Ribble Valley Borough Council  
Council Offices  
Church Walk,  
Clitheroe  
Lancashire  
BB7 2RA

Phone: 0300 123 6780  
Email: [developeras@lancashire.gov.uk](mailto:developeras@lancashire.gov.uk)  
Your ref: 3/2025/0754  
Our ref: 3/2025/0754/HDC/KW  
Date: 11 November 2025

**Location:** Unit B Bee Mill Preston Road Ribchester Lancashire PR3 3XL  
**Proposal:** Proposed change of use from Class E to Class B2 for peanut butter production.  
**Grid Ref:** 364839 435365

Client	Freda's Peanut Butter
Job	Bee Mill, Ribchester
Title	Box Van - Swept Path Analysis

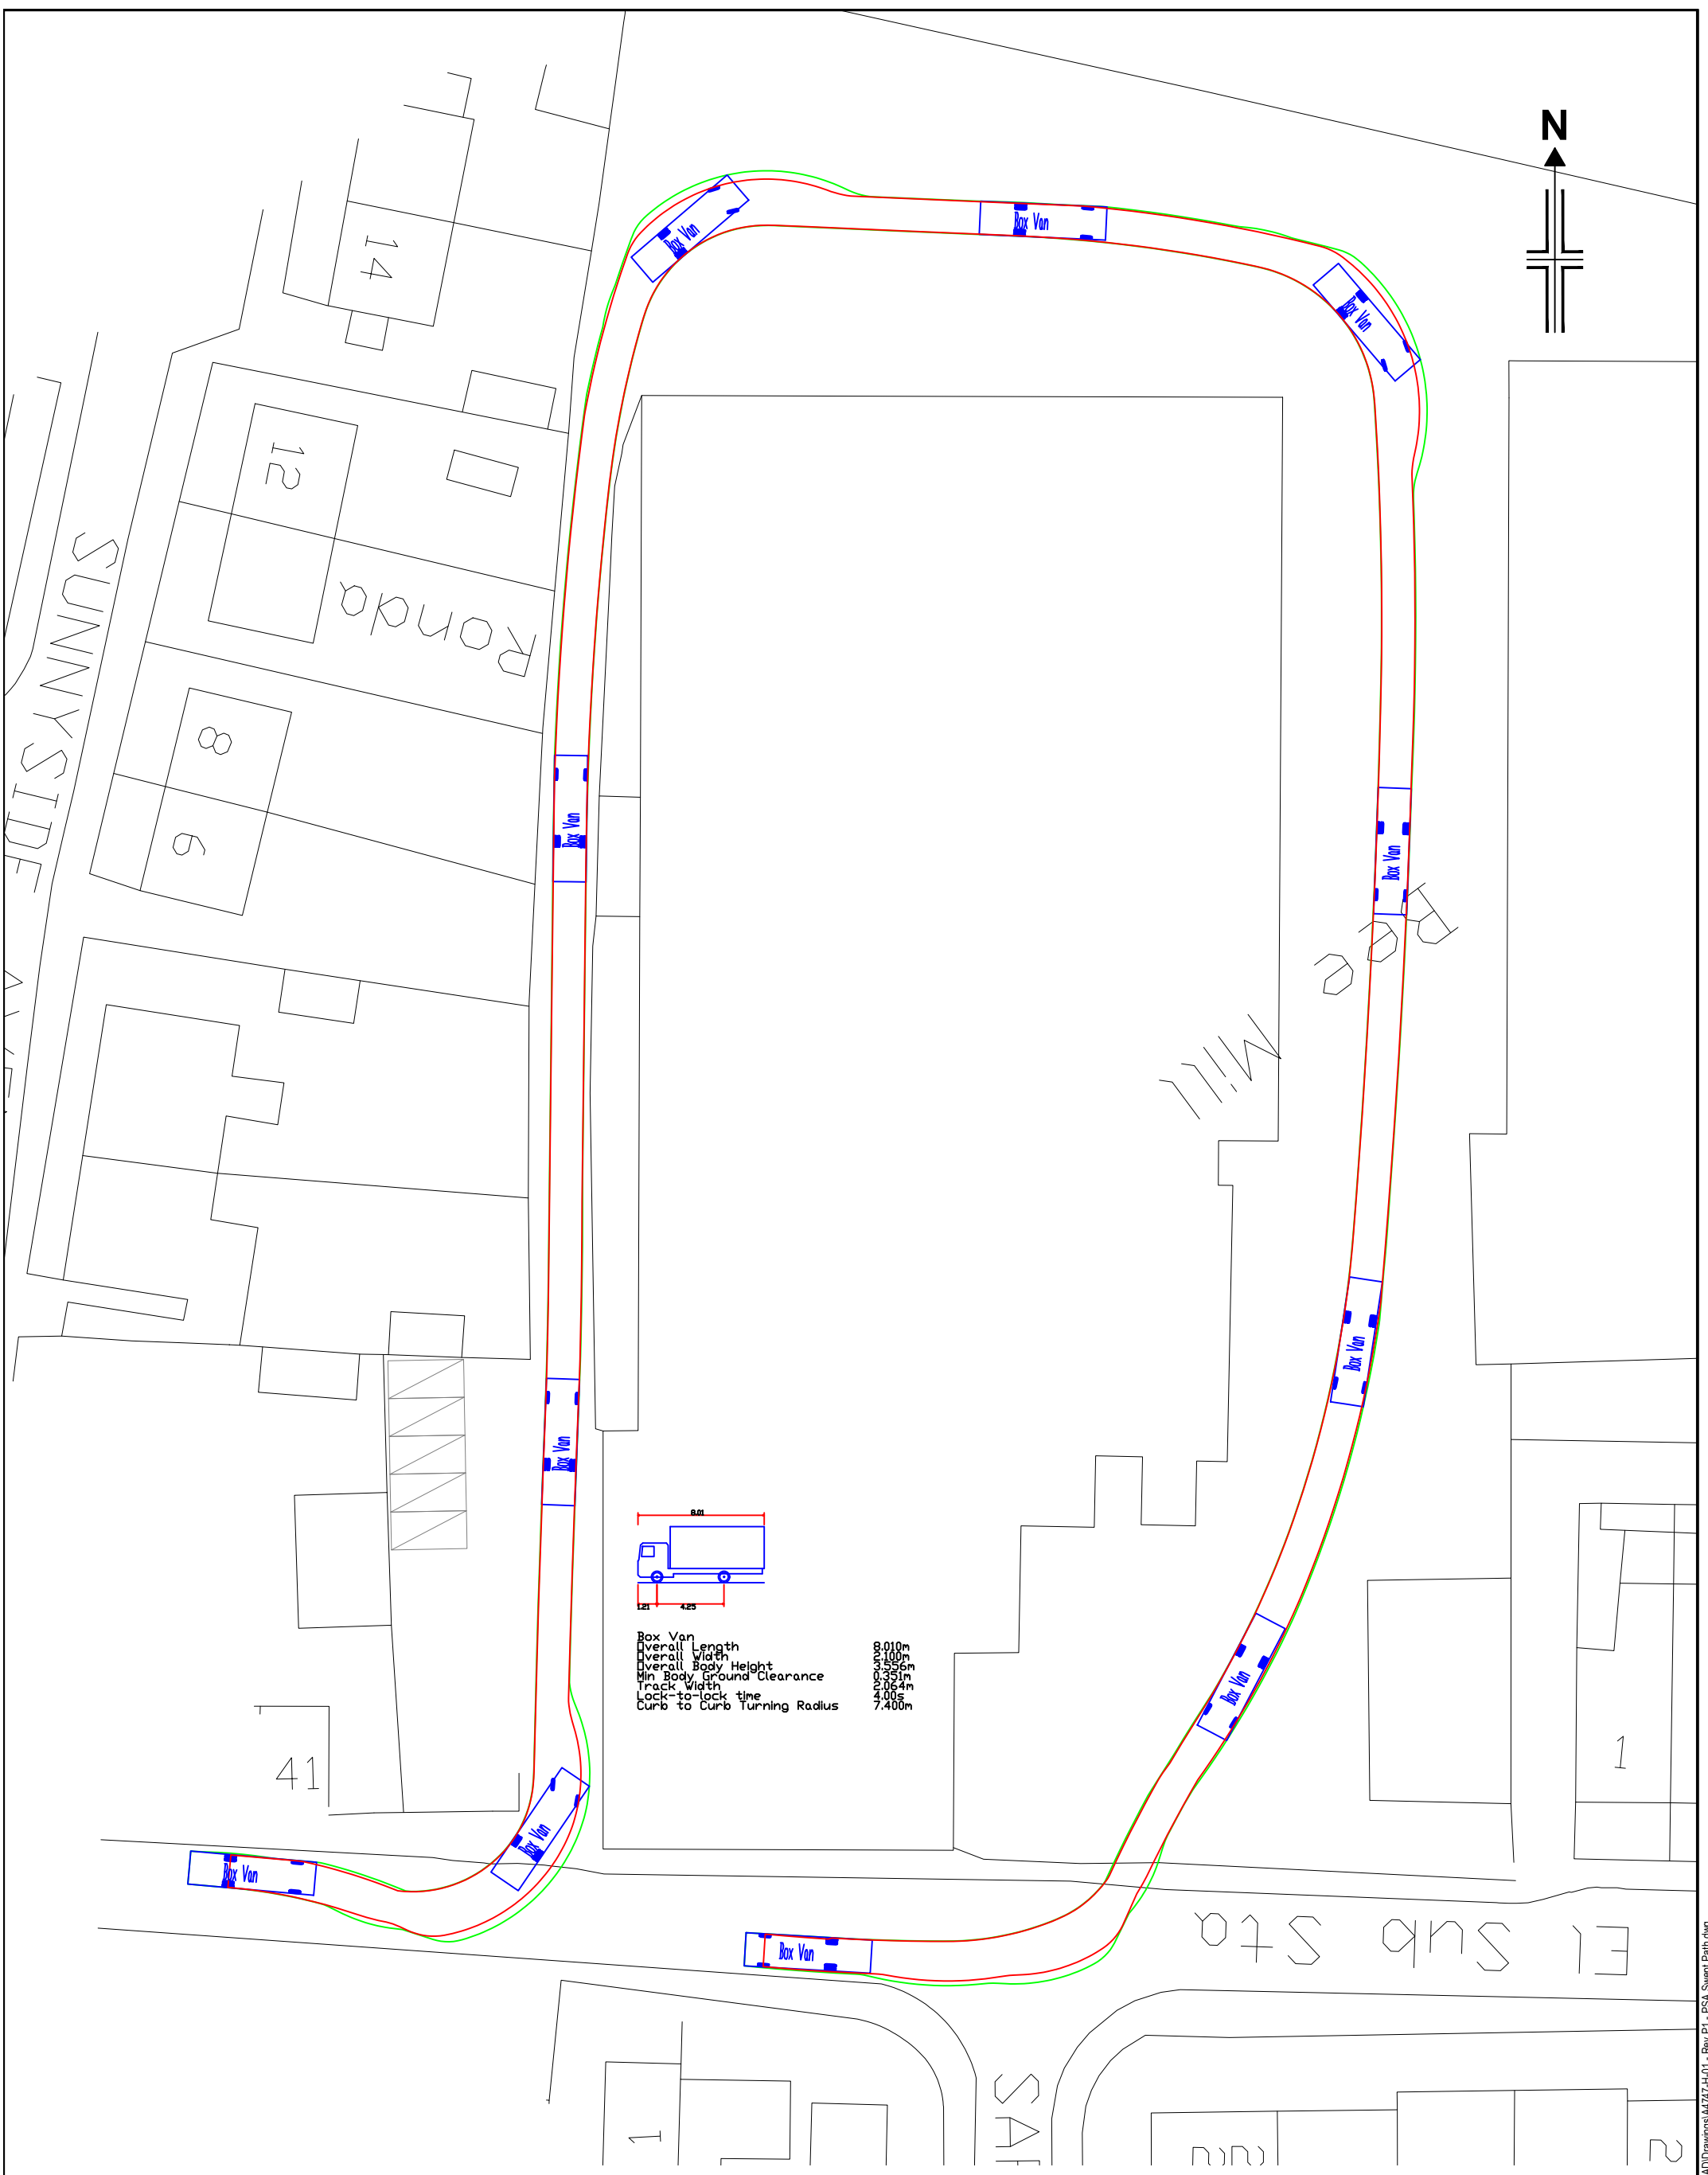
- Types of vehicles expected to access the site
- Frequency and timing of deliveries and collections
- Designated delivery areas and swept path analysis for the largest vehicle expected to access the site to demonstrate safe manoeuvring
- Detailed access arrangements, including widths
- Service and delivery routes on the wider network.

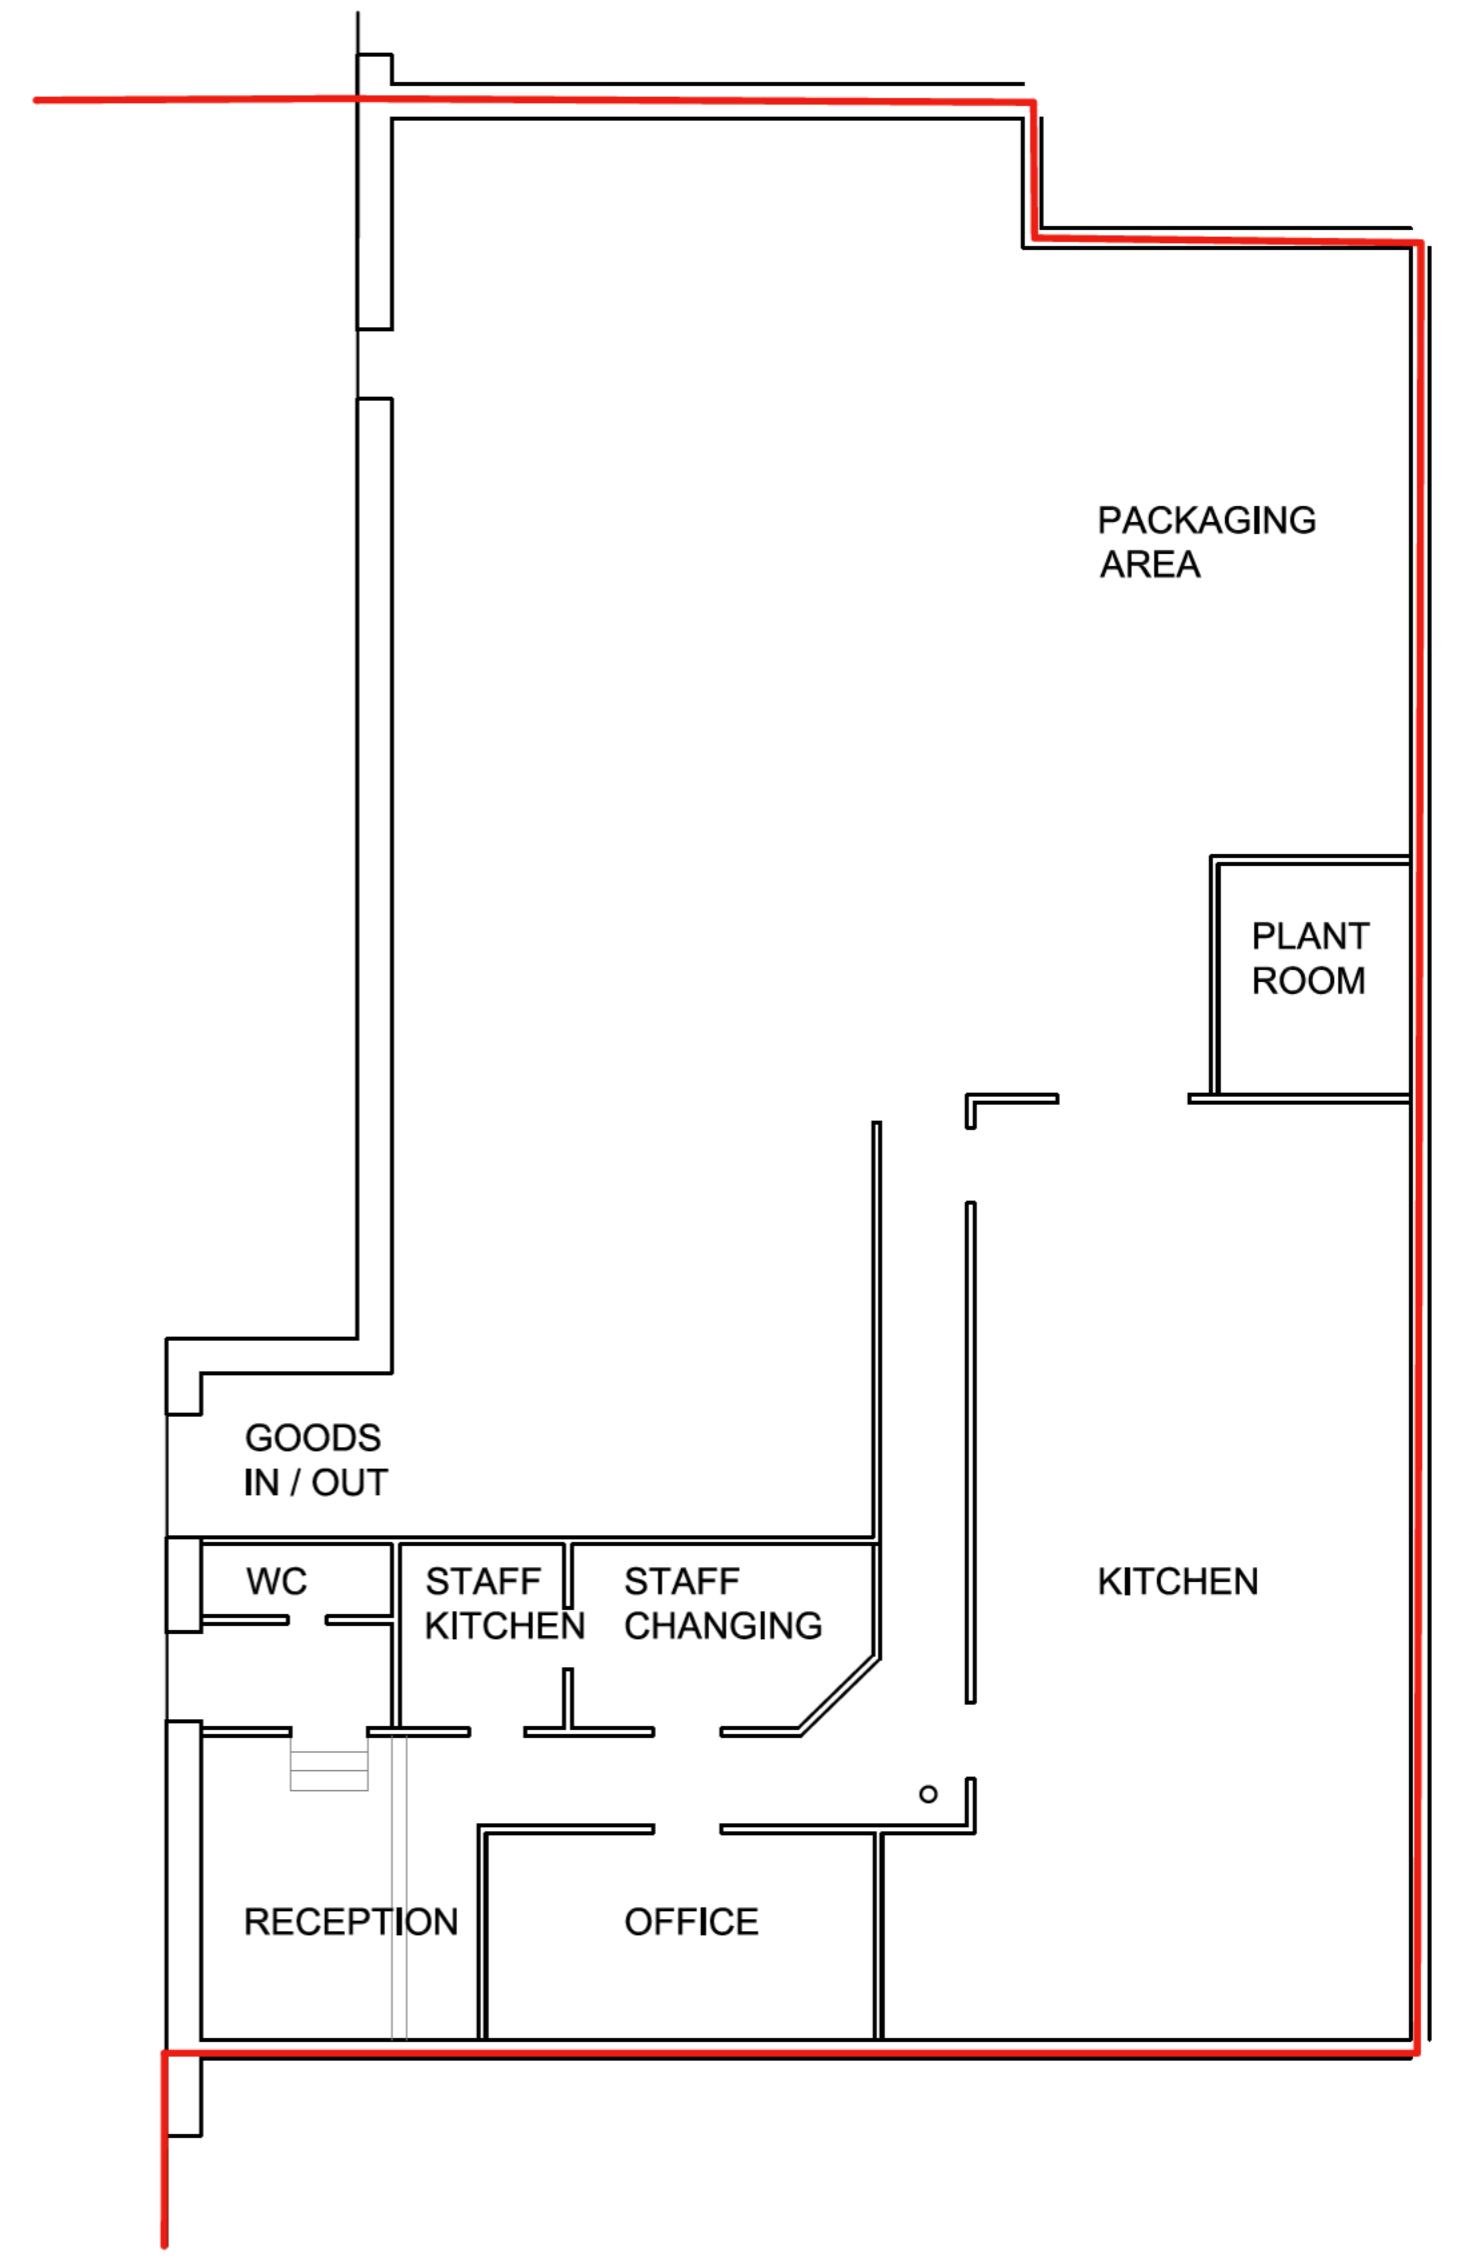
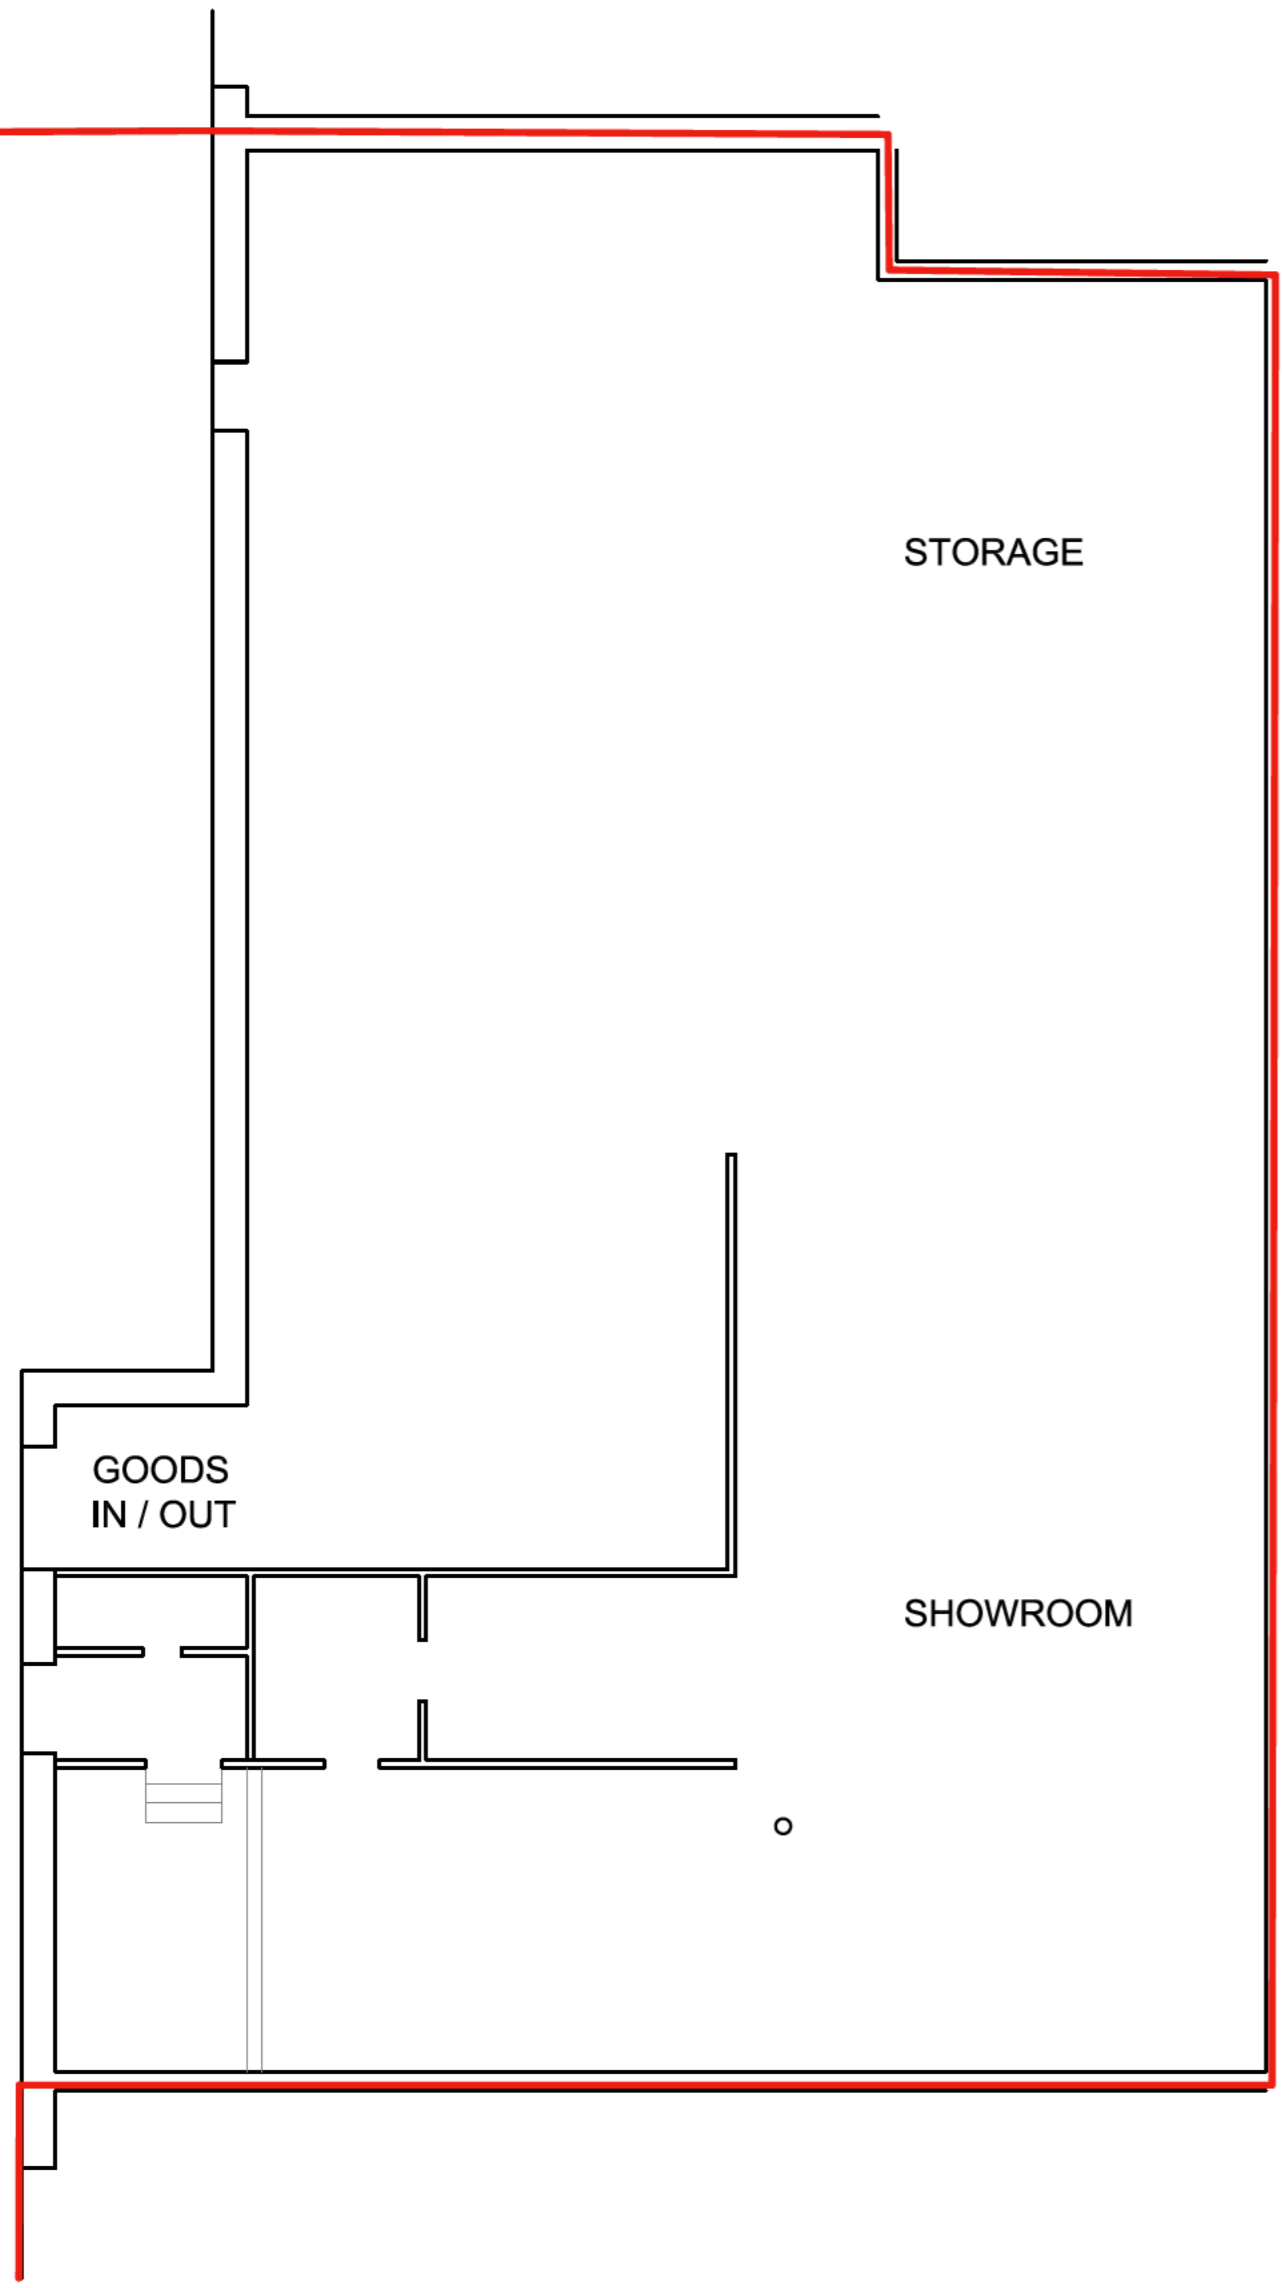
The LHA have reviewed the Existing and Proposed Plans and are aware that the internal gross floor area is 354 square meters. In line with the parking standards as defined in the Joint Lancashire Structure Plan a Class B2 use should provide parking at a ratio of 1 space per 45 square metres. Applying the Joint Lancashire Structure Plan parking standard yields a requirement of 8 parking spaces. The current provision, therefore, represents a shortfall of three spaces.

Whilst the applicant has stated that no customers will visit the site, they have not shared the number of employees likely to be employed at the site, which may help provide a clearer picture of the parking demand. As such the LHA would request that the applicant provide an estimate of how many staff members are likely to be employed within the site and their likely working hours.
